Cambridgeshire County Council

Sunnica Solar Energy Farm

Planning Inspectorate Reference: EN010106

Written Representations

MSTL551 - Sunnica Energy Farm Reporting Zone A  
 Figure A7 - Magnetic Gradient (Overview) (North)  
 1:5,000 @ A3  
 Copyright Magnitude Surveys Ltd 2020  
 Contains Ordnance Survey data © Crown Copyright and database right 2020

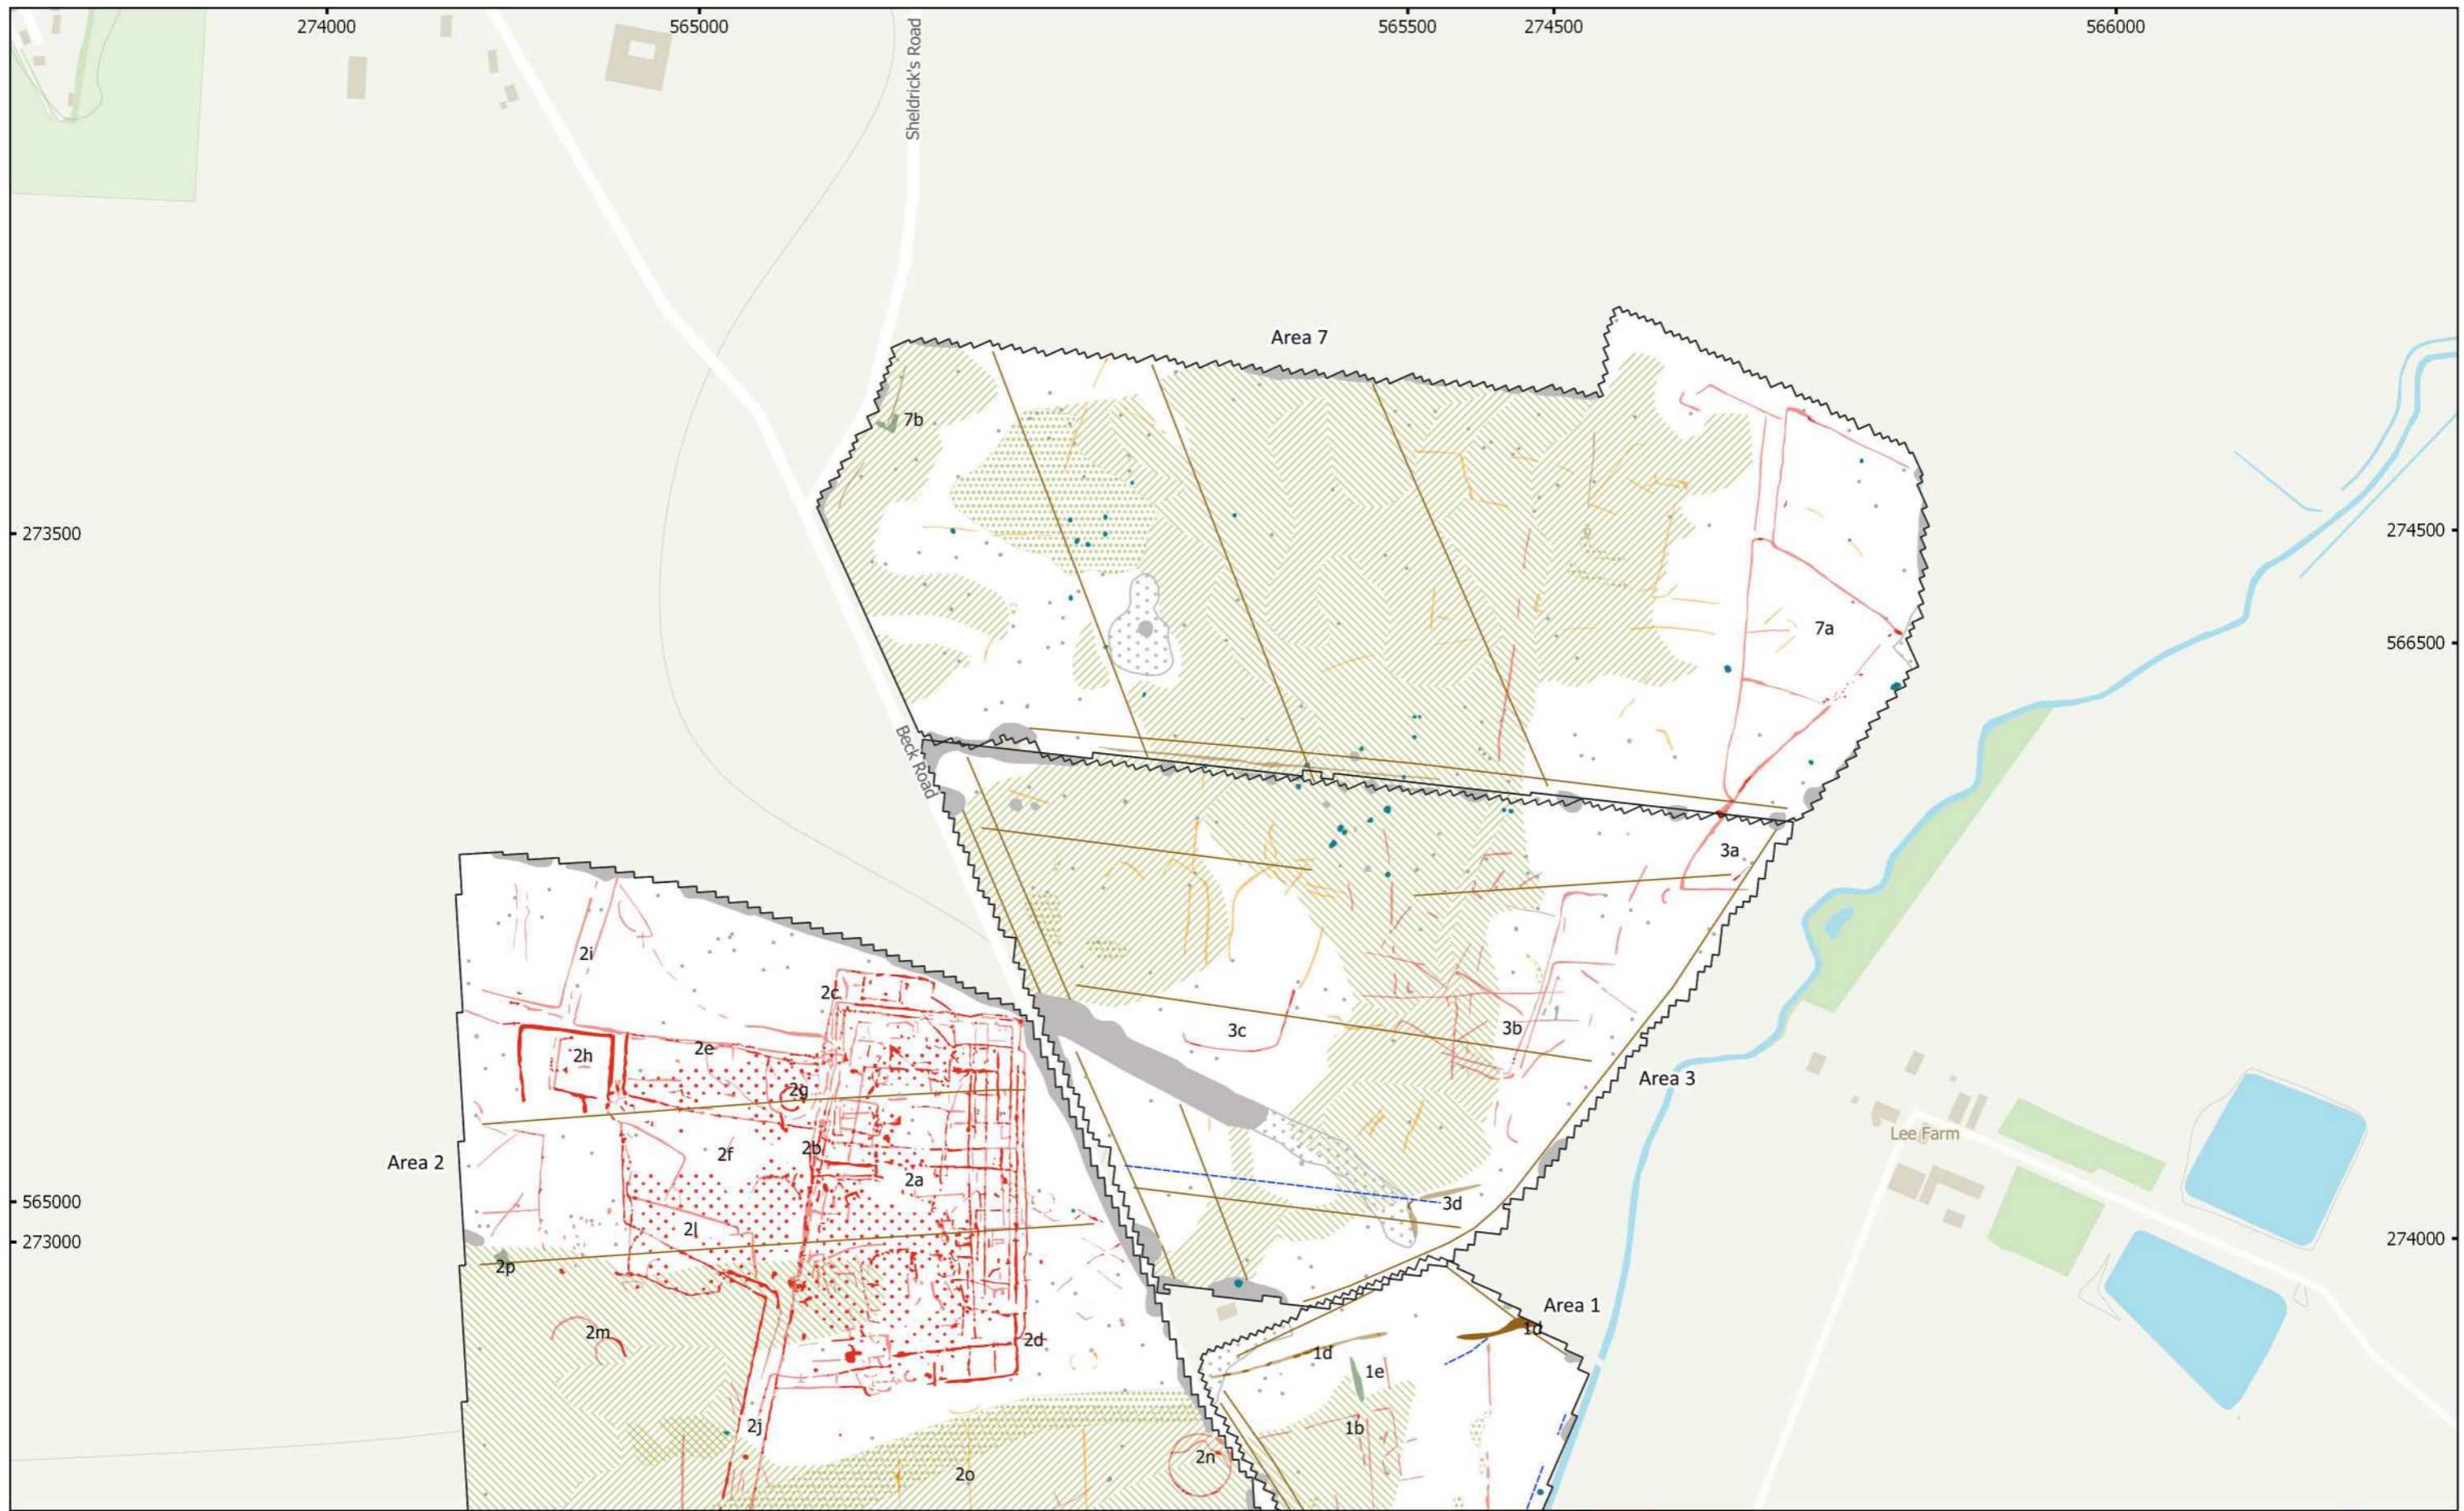
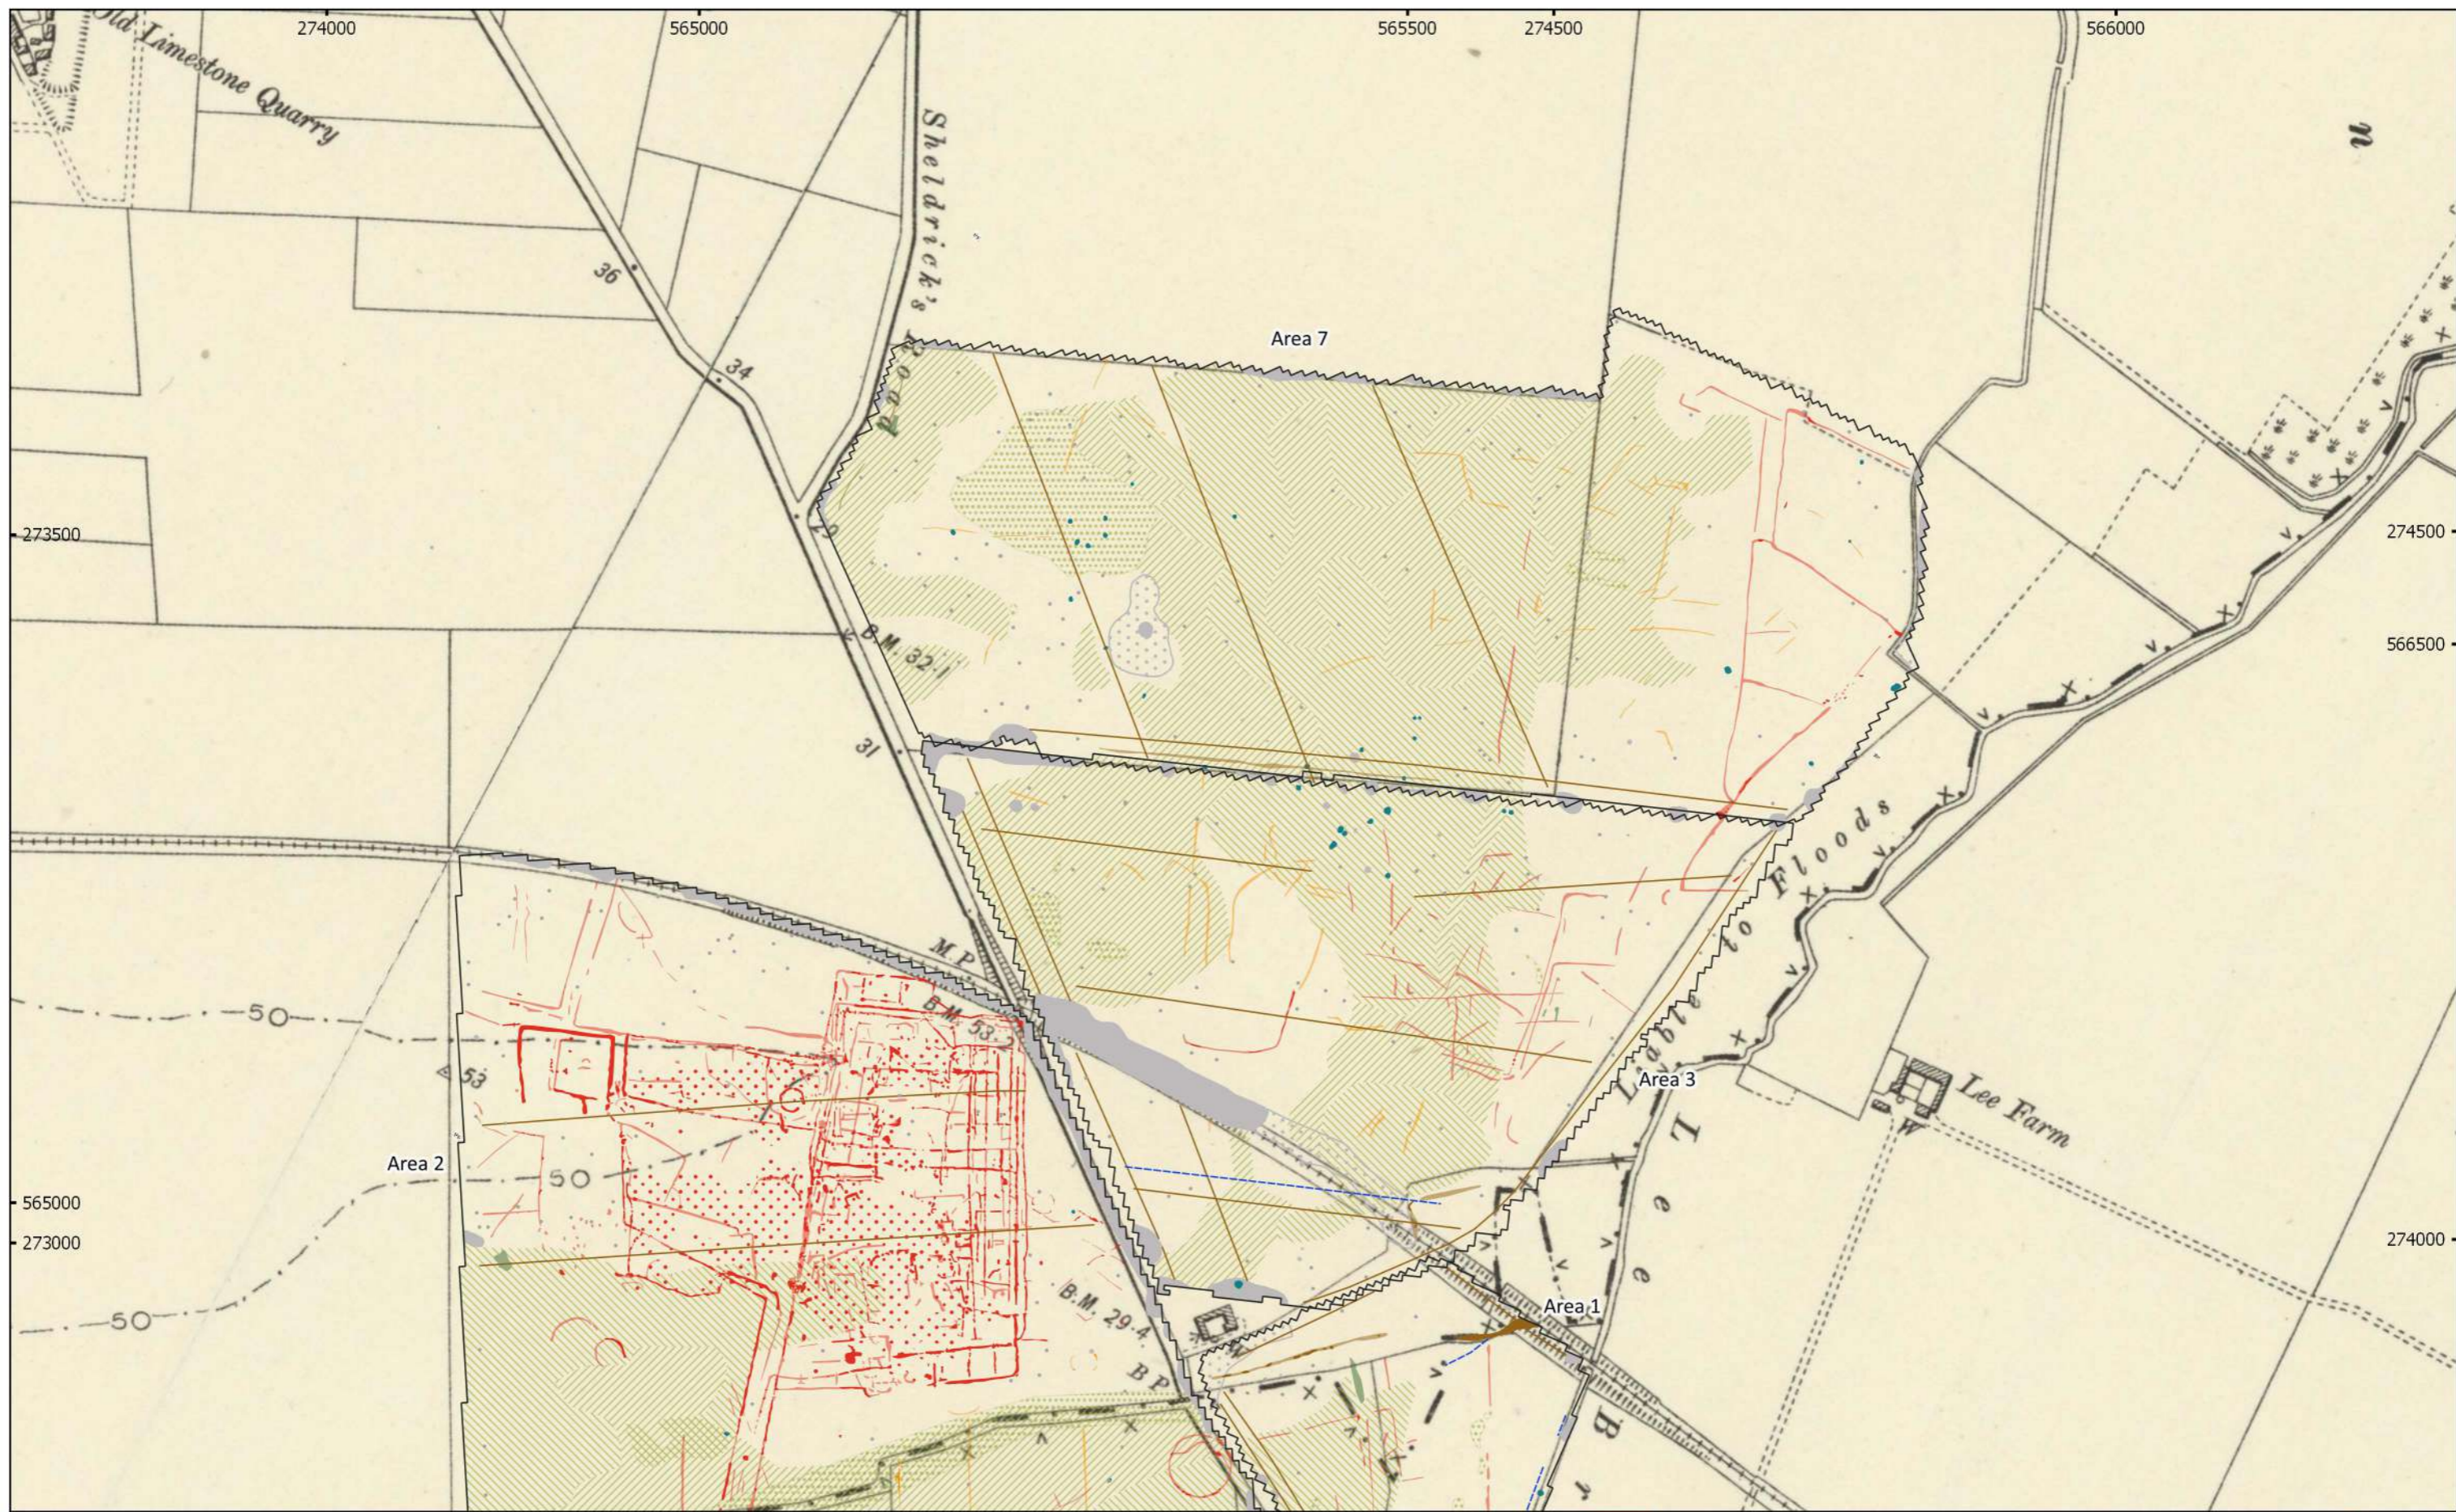
- 2.11 Geophysical Survey plots Figure A7-A9 and A33 (APP-063) show a strong dipolar anomaly, which in hindsight is the crash site (please see attachment 'Sunnica East E05 GS Zone A crash site'). Although it seems strange to have avoided it, the dipolar anomaly did not receive a test trench to check it due to a common assumption that the strong dipolar signal usually means the burial of farm rubbish and potentially contaminated land – all too often seen and often hazardous to deal with. Archaeologists do not deal with contaminated land issues and leave this to other professionals.

- 2.13 The councils consider that it would be inappropriate to develop the site of the crash with photovoltaic panels but that an agreed space around it be clear of panels, fenced, grassed, and a small memorial stone established to mark it instead. A path to the memorial from a proposed footpath to be developed at the western field boundary is another possibility for consideration in the design of the solar array.
